From: Laura Gibbons <Laura.Gibbons@arun.gov.uk>
Sent: 27 April 2021 10:42
To: Planning.Responses <Planning.Responses@arun.gov.uk>
Cc: Simon Davis <Simon.Davis@arun.gov.uk>
Subject: Y/22/21/PL- North Barn, Hoe Lane, Flansham

Thank you for consulting us on this application. We have the following comments on surface water drainage.

Title
AQUAFLOW PERMEABLE PAVING
FORMATION AND CONSTRUCTION DETAILS

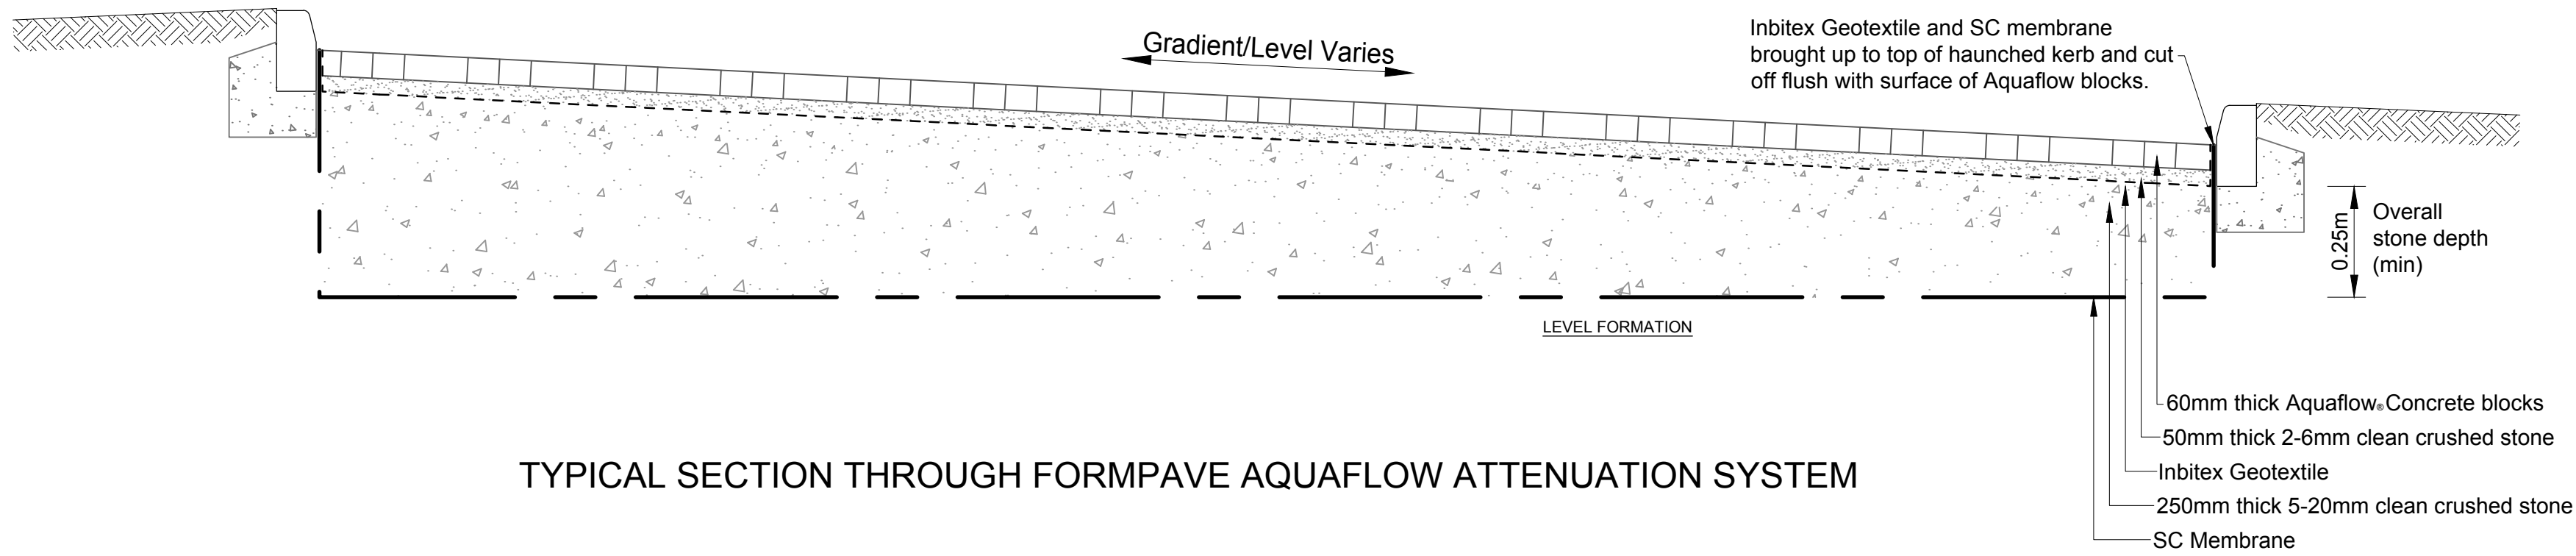
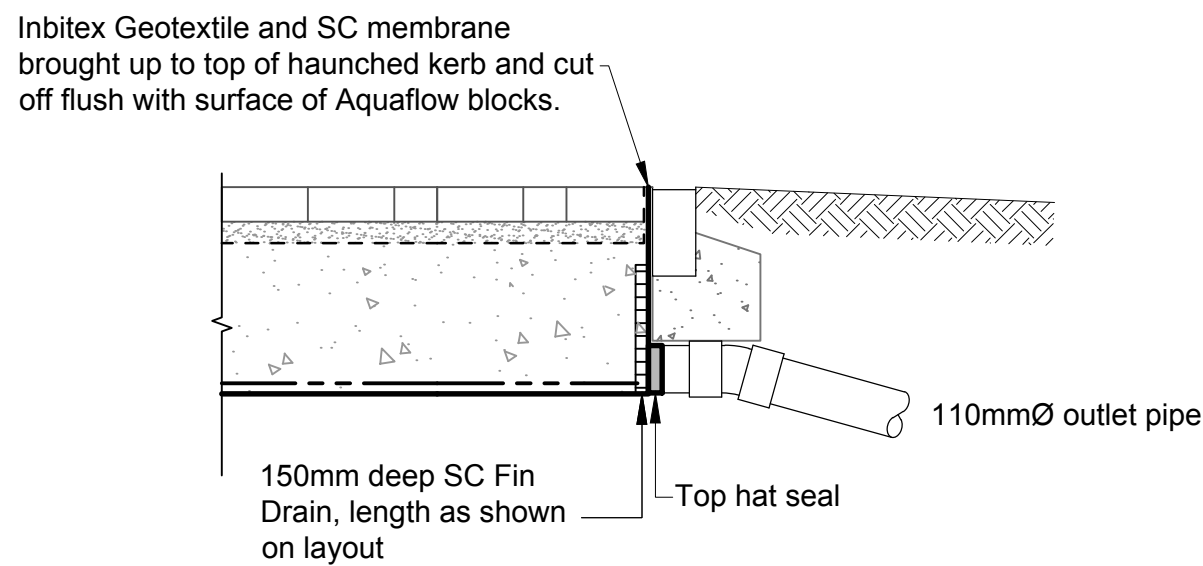
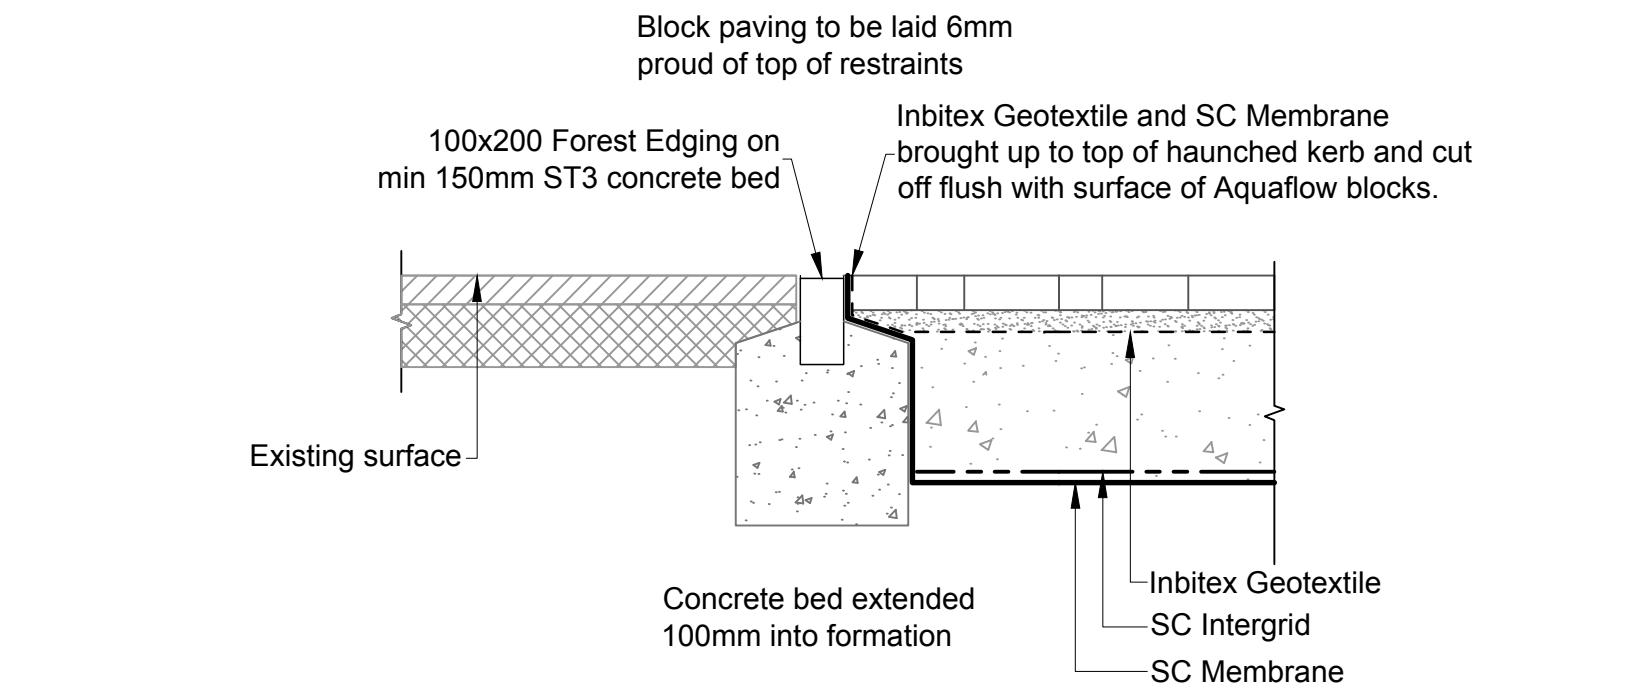
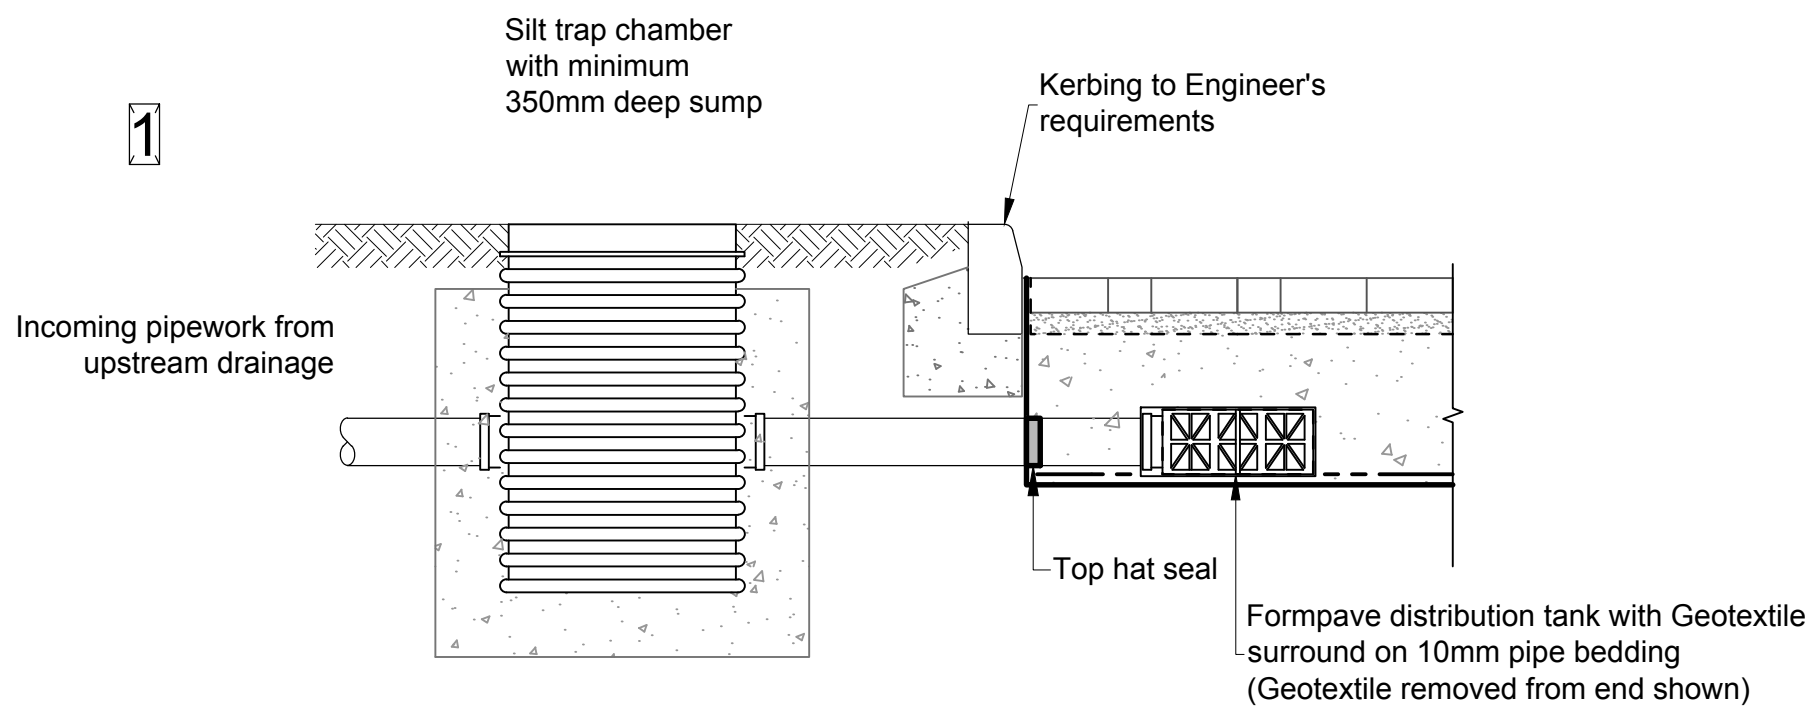
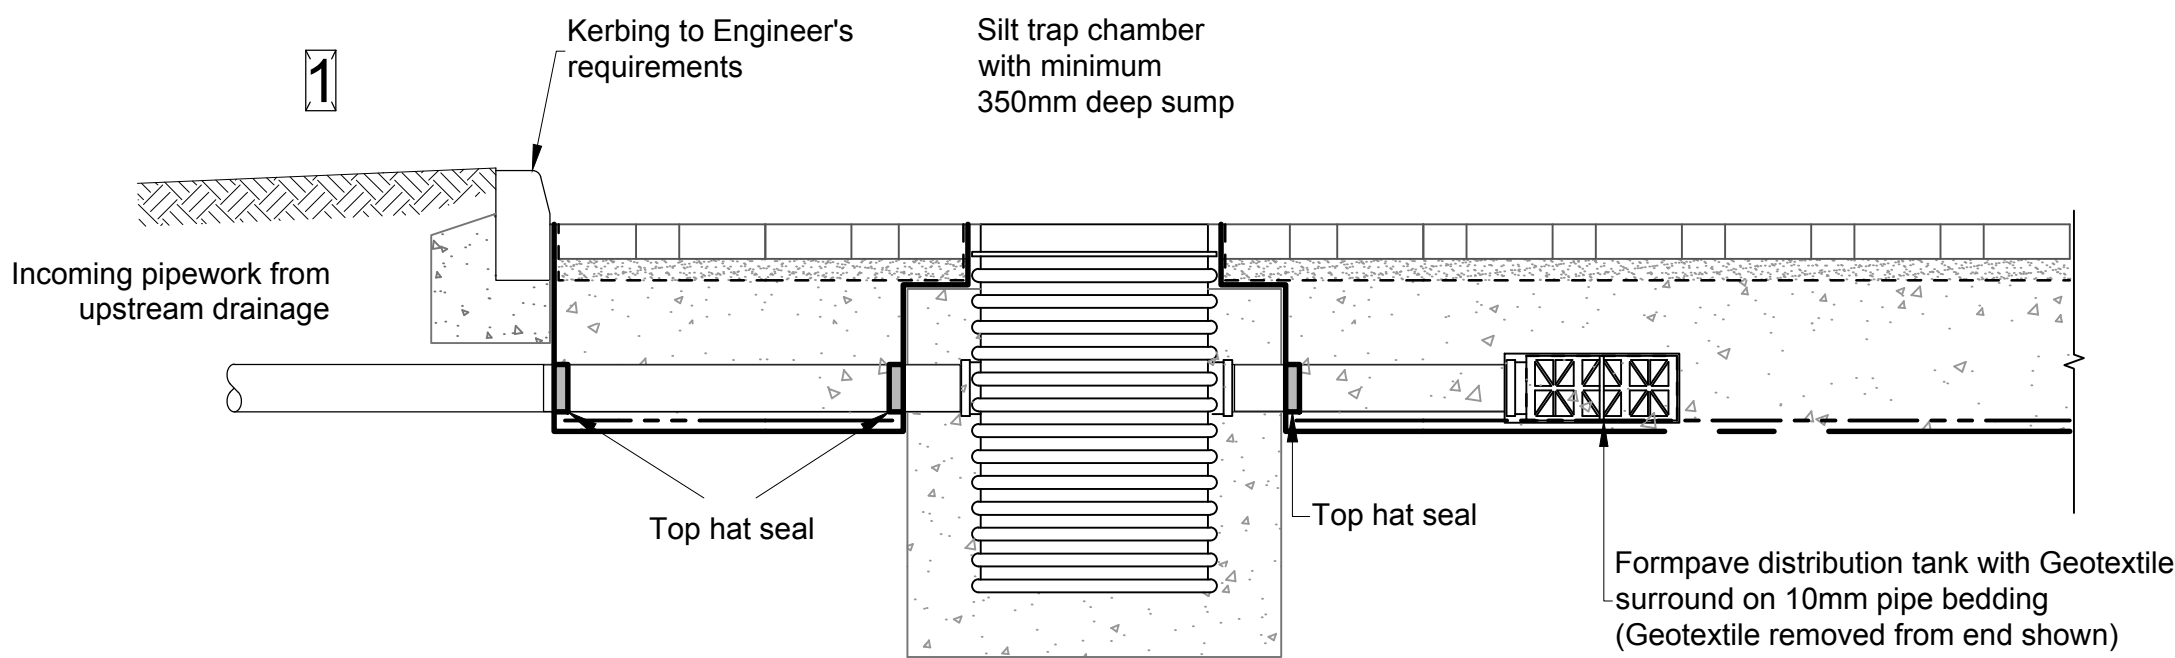
2. the permeable paving. However, the total construction depth of permeable paving is now proposed to be 360mm, which means groundwater (observed at 495mm bgl) is clear of the base. The decision to line should be reconsidered to allow infiltration in drier conditions.

5. It should be clearly stated on plan whether the formpave formation level is to be even. It is noted from the standard construction detail that the formpave formation level is flat, please confirm if this is to be the case and add a note on the layout.
